From: Richard Temple
Sent: 14 February 2018 15:23
To: Karen Parsons
Subject: FW: Ref Planning Application FP/268/17/PL update

From: Roger Spencer
Sent: 12 February 2018 11:35
To: Richard Temple
Subject: FW: Ref Planning Application FP/268/17/PL

Subject: Ref Planning Application FP/268/17/PL

Low Timber Wall (Plan)

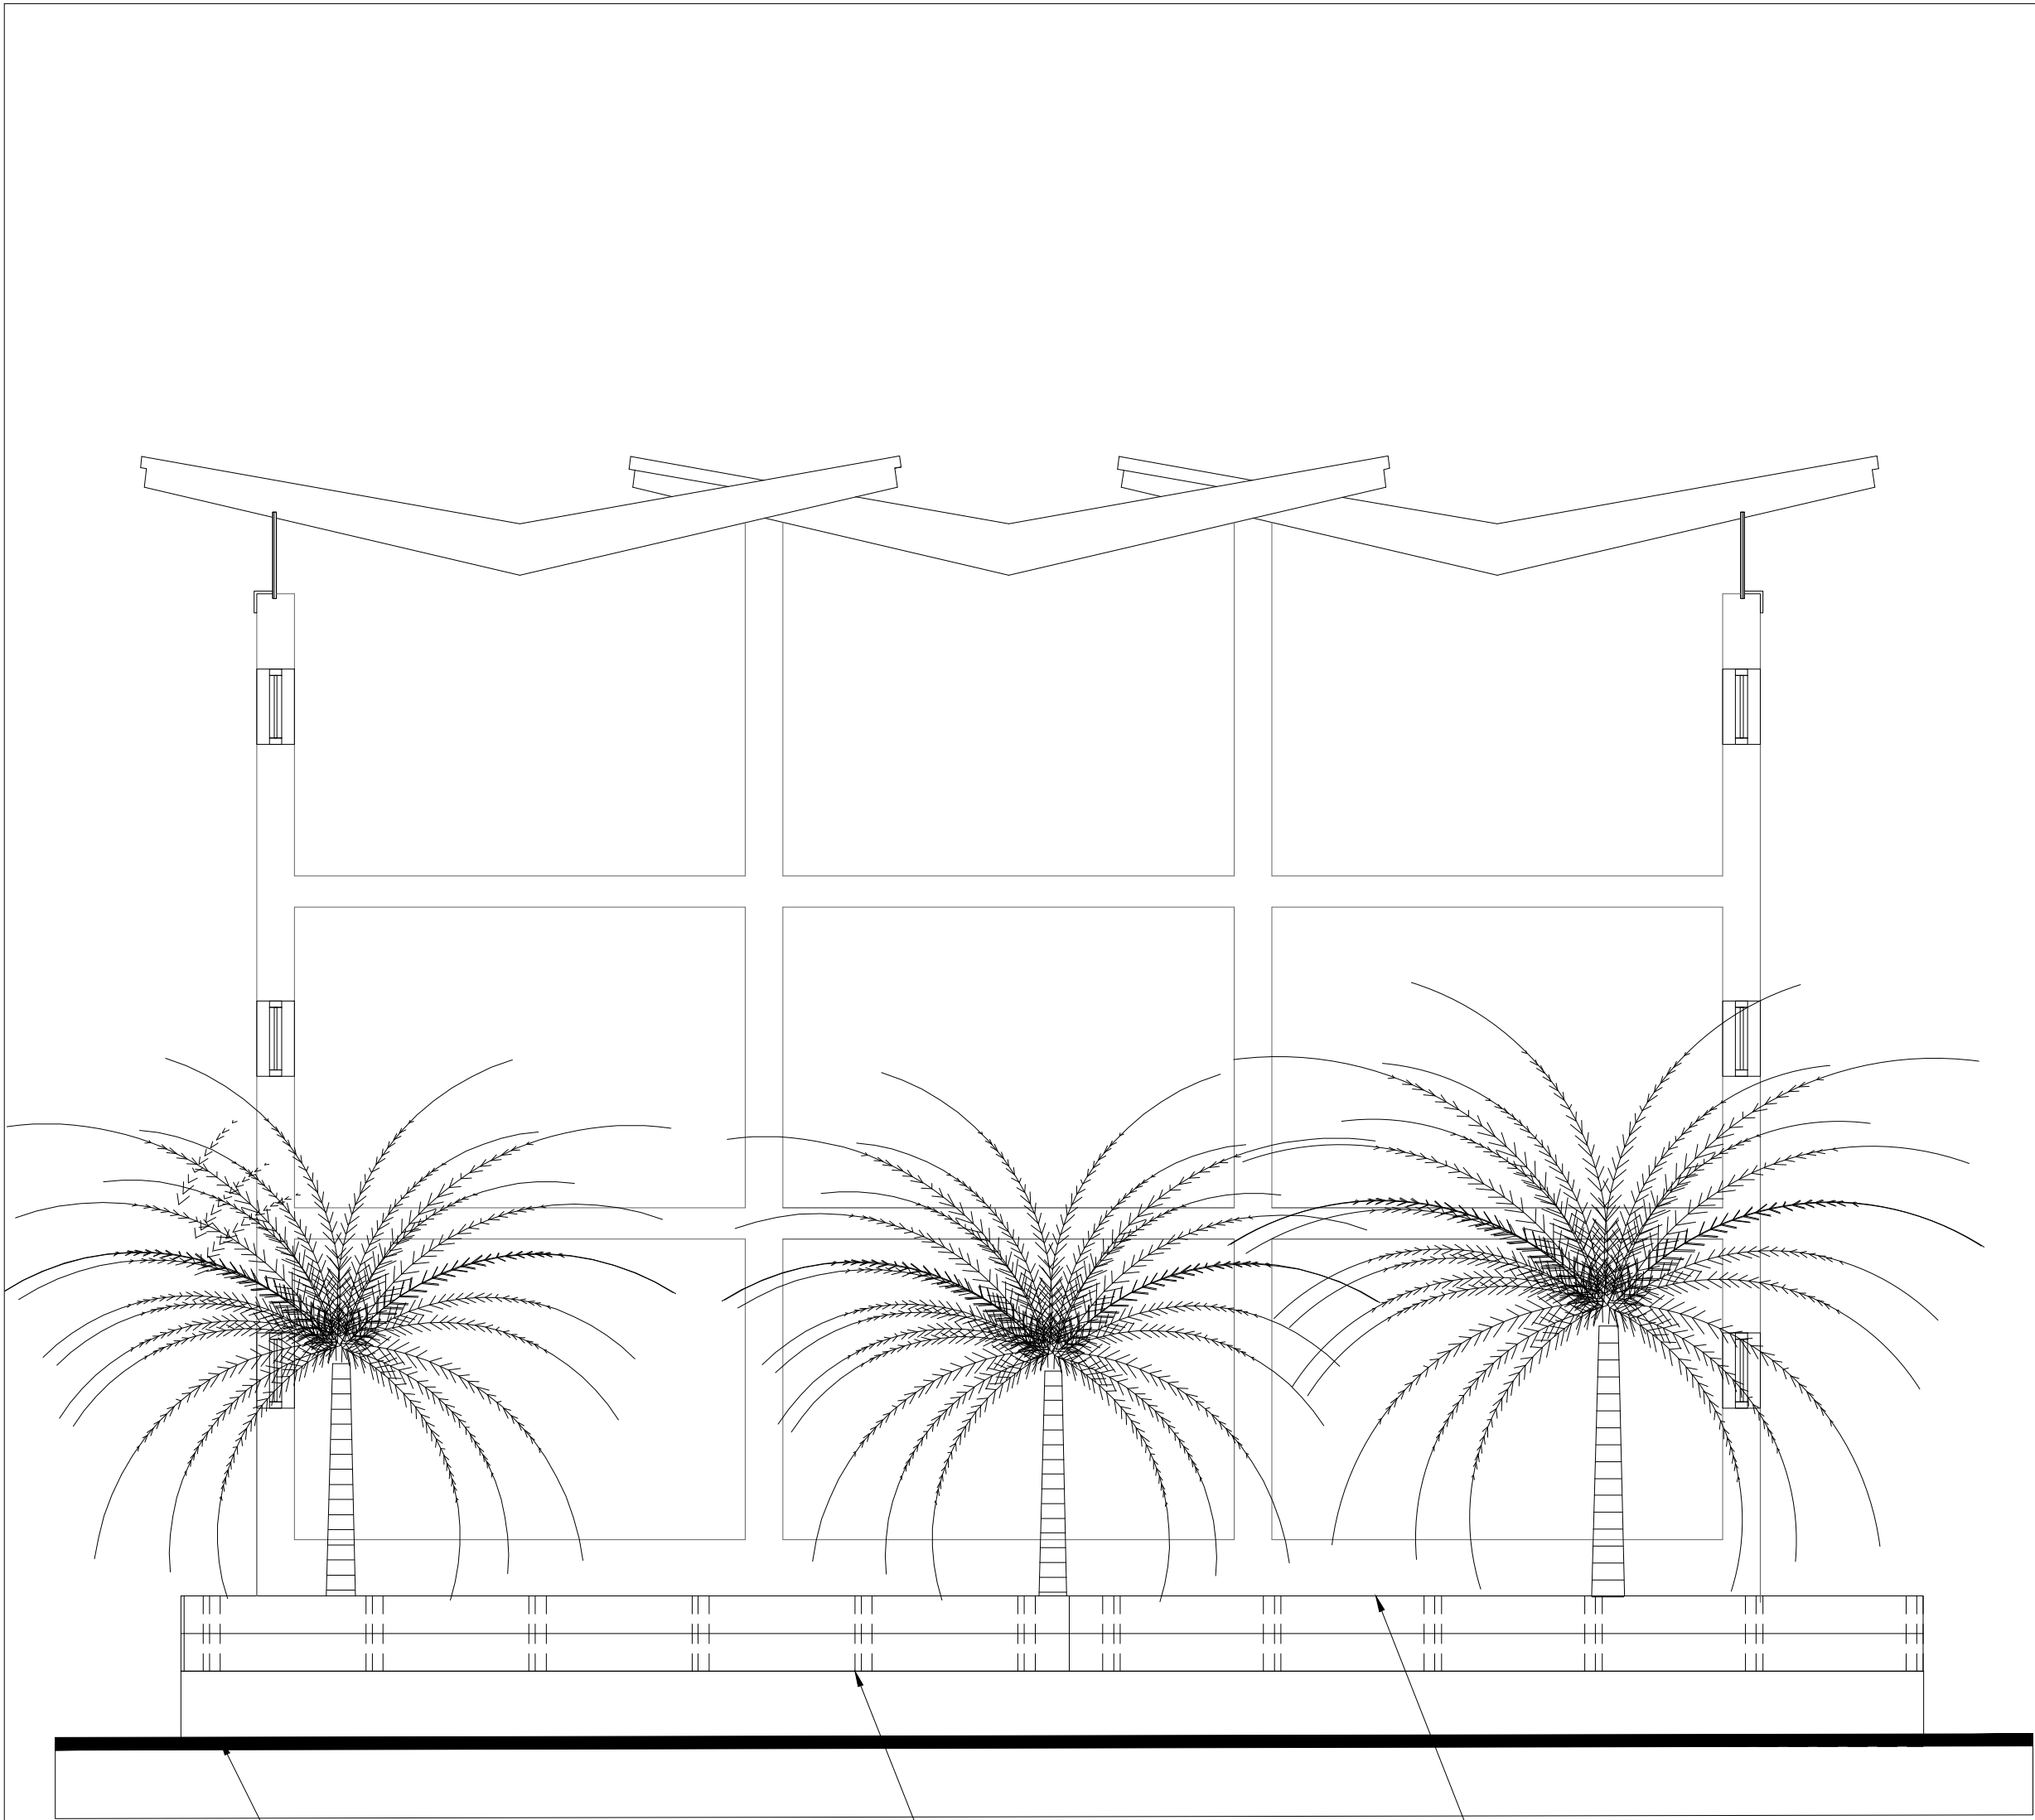
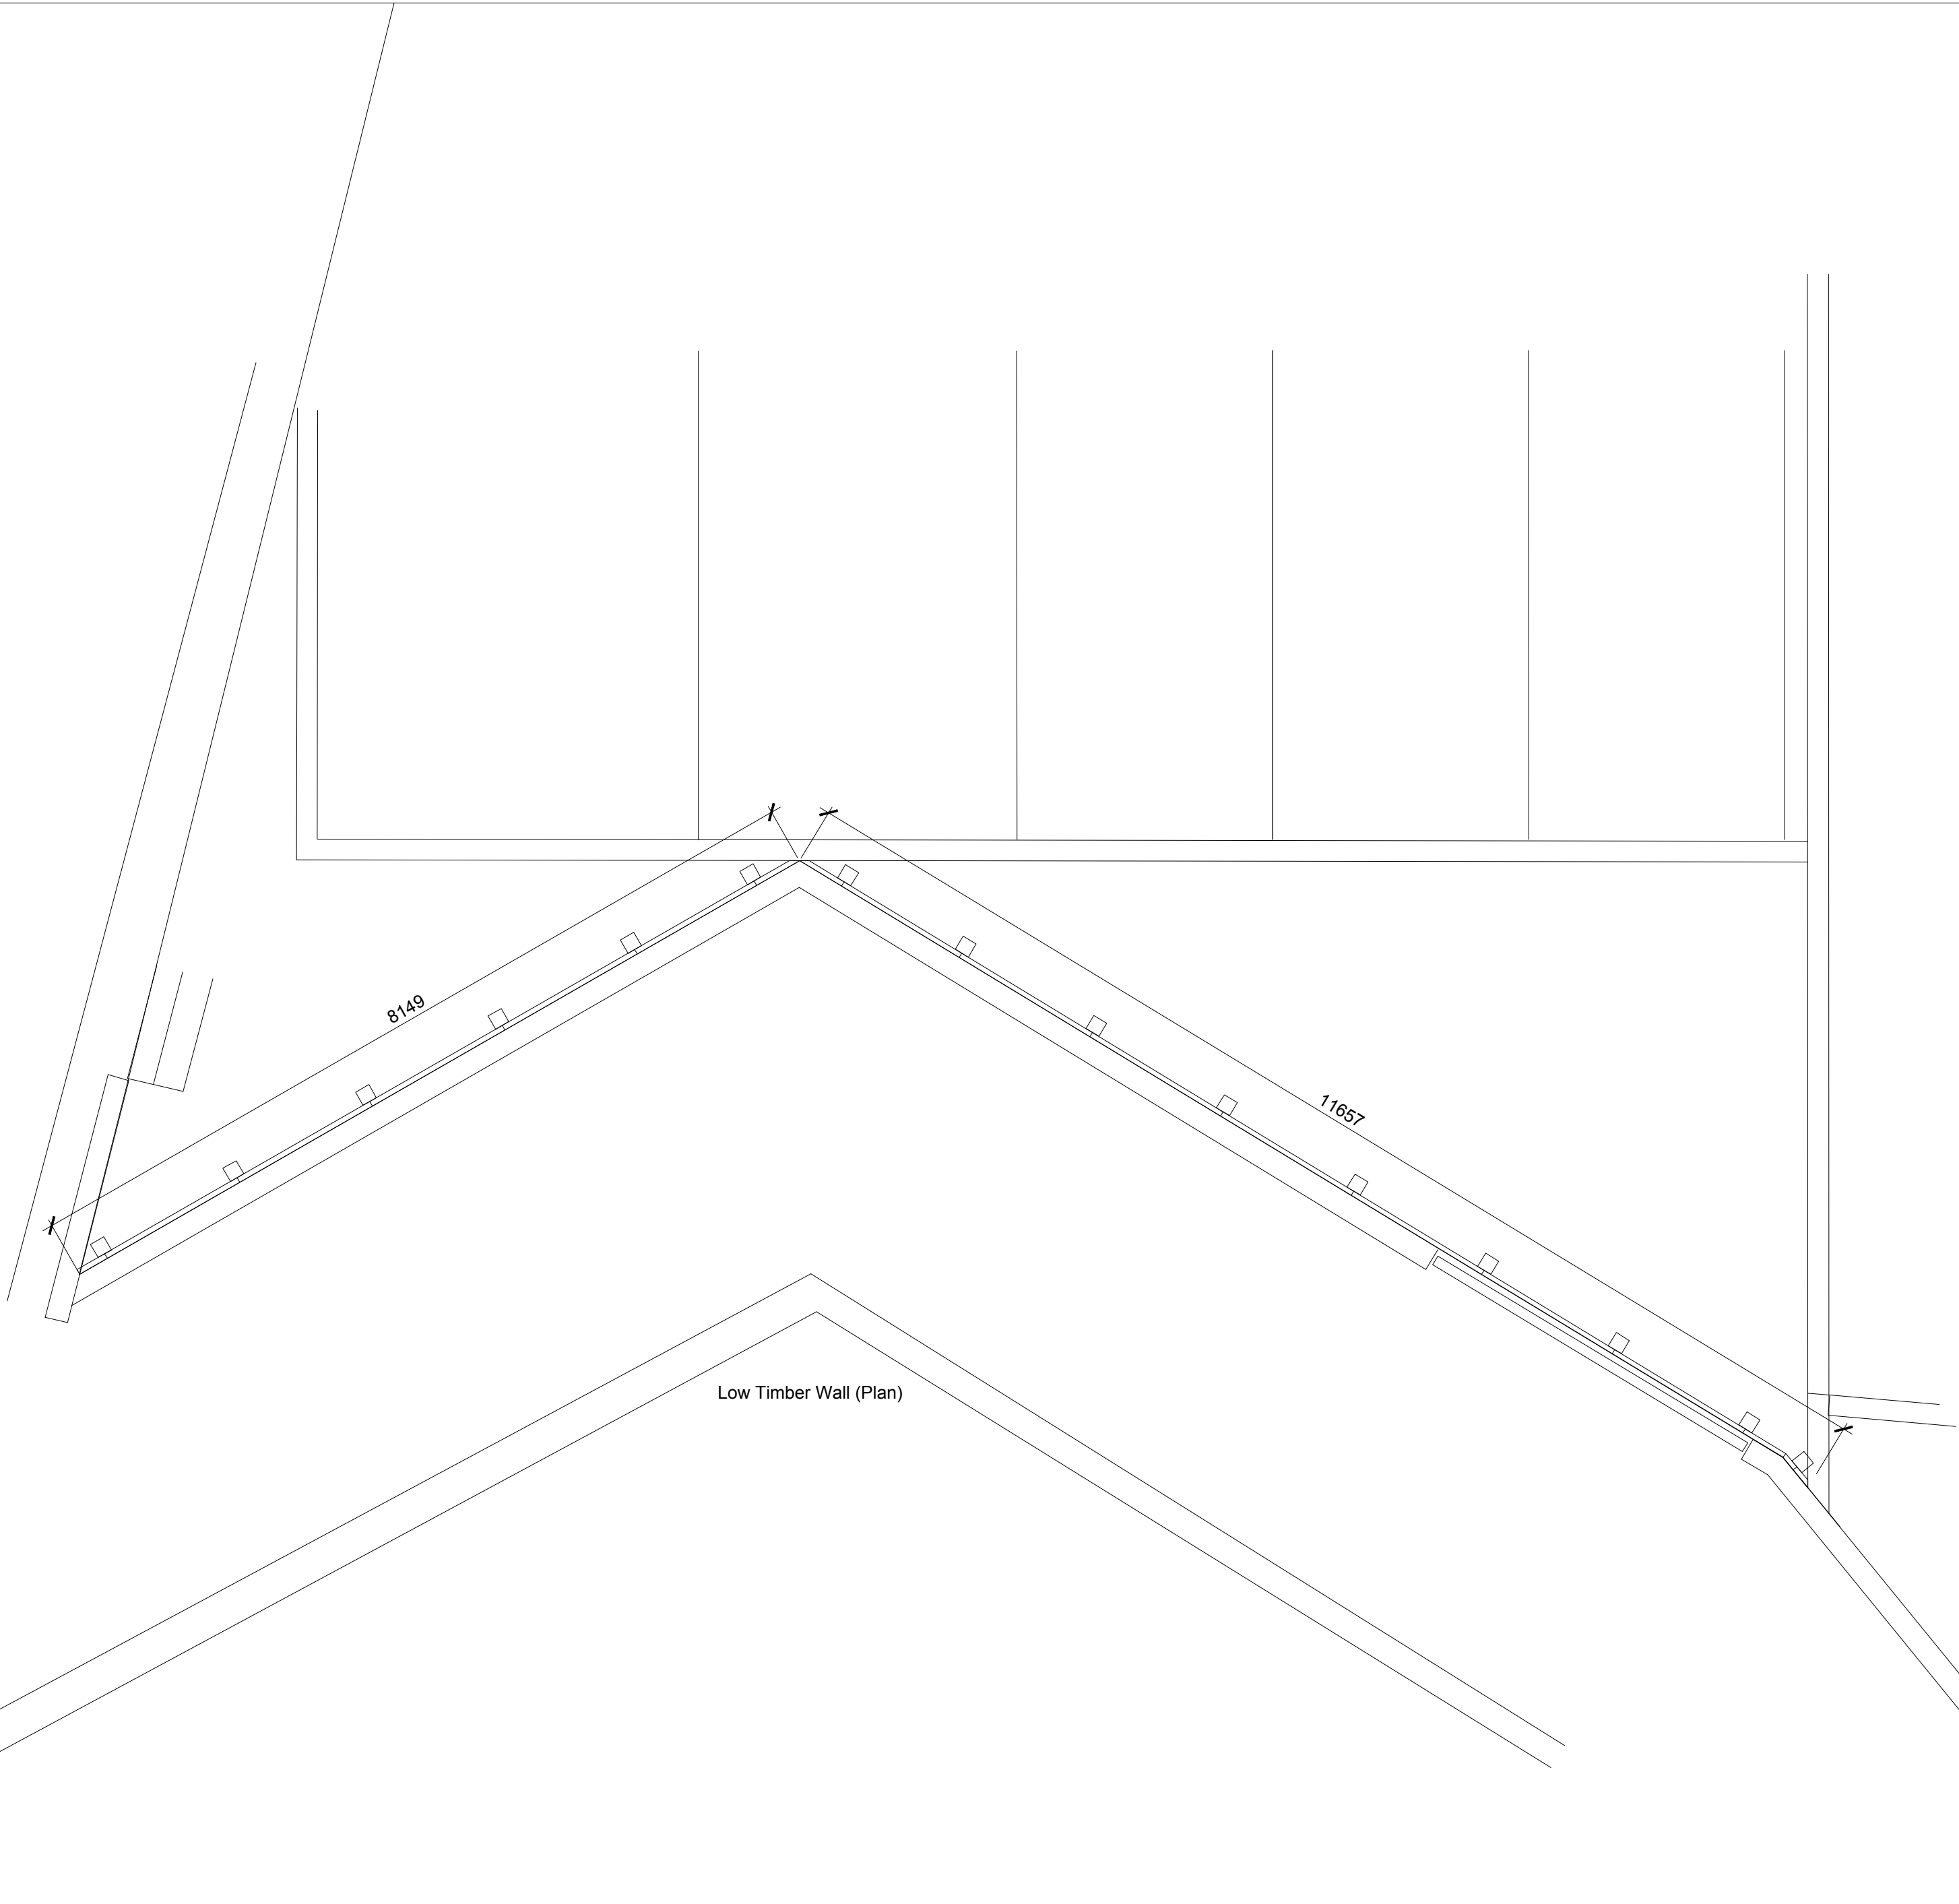
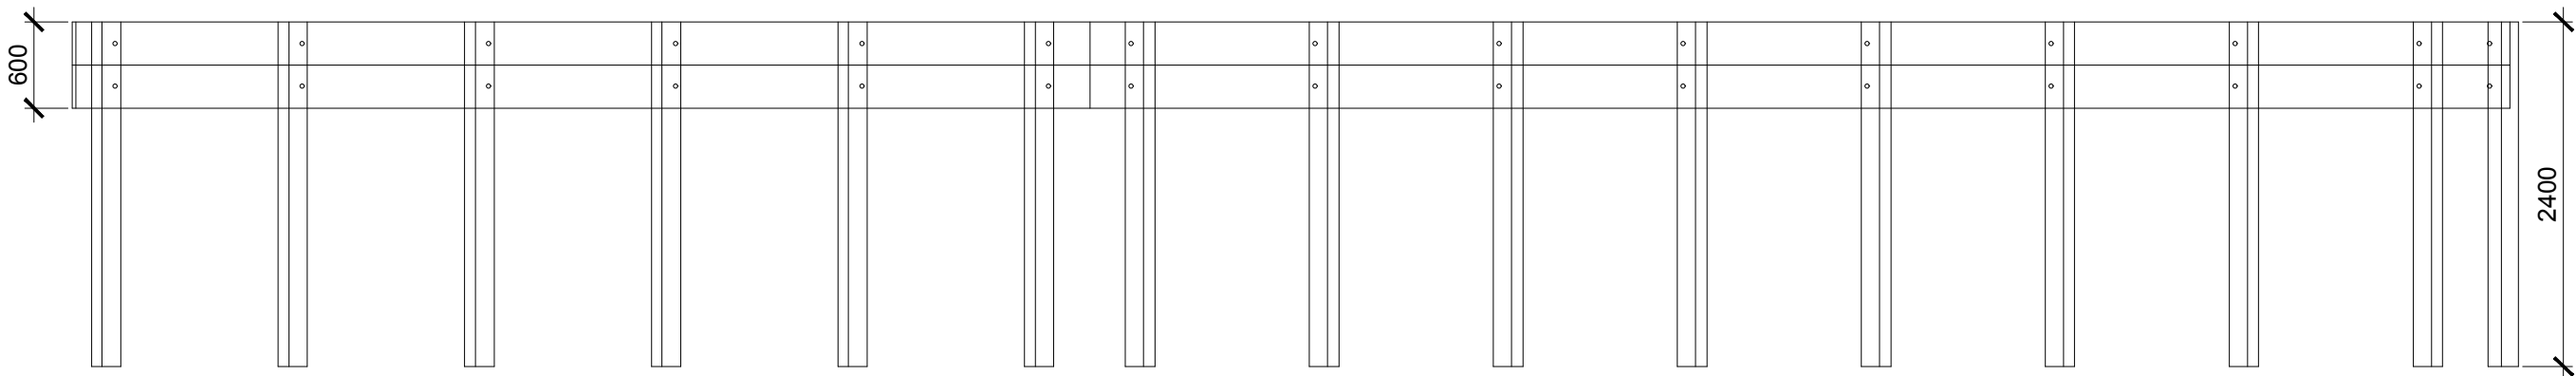
Thank you for turning round my comments -- what you have shown on your Drg LLD1268-LAN-DWG-400 is more to my way of thinking.

I note that you have shown 2 No. 300mm high (x 50mm wide) planks to make up that 600mm. The 300mm width is not usually an economic section -- it may be worth considering 3 x 230mm (9") -- this would necessitate the post to be raised slightly to support the extra 90mm?? However, I consider either (600mm or 690mm above the rear splash-wall) to be reasonable.

However, I would urge you to change the min 1500mm centres to "max"

I would also suggest that you reconsider the fixing detail. As it stands, with the fence tight up against the back of the seawall, you wouldn't be able to fix the planks to the posts - suggest that you fix the posts against the wall then start the planks on top of the wall. You may have considered that we

wouldn't like this encroachment over the seawall but I think it is preferable to your current detail. Sitting the bottom plank on top of the wall would also provide for a better seal too.

I assume that you'd concrete the posts into the ground, as I wouldn't want to put more loading onto our seawall by fixing into the back of it. Please also consider that digging out for the concreting in may be a little problematic – I'm not sure what the construction would have been in the 1960s when the seawall went in.

Further to your last e-mail, please find attached drawing detailing the low timber wall running behind the existing promenade wall, as noted on the landscaping drawing.

- Made of sustainably sourced hardwood, ideally matching the material used for timber groynes located adjacent to the site.
- Posts to be min. 150x150x2400mm set at min. 1500mm centres.
- Timber Boards / Planks to be min. 50mm thick, length to match layout of the posts.
- All of the dimensions and specifications to be confirmed by the engineer.
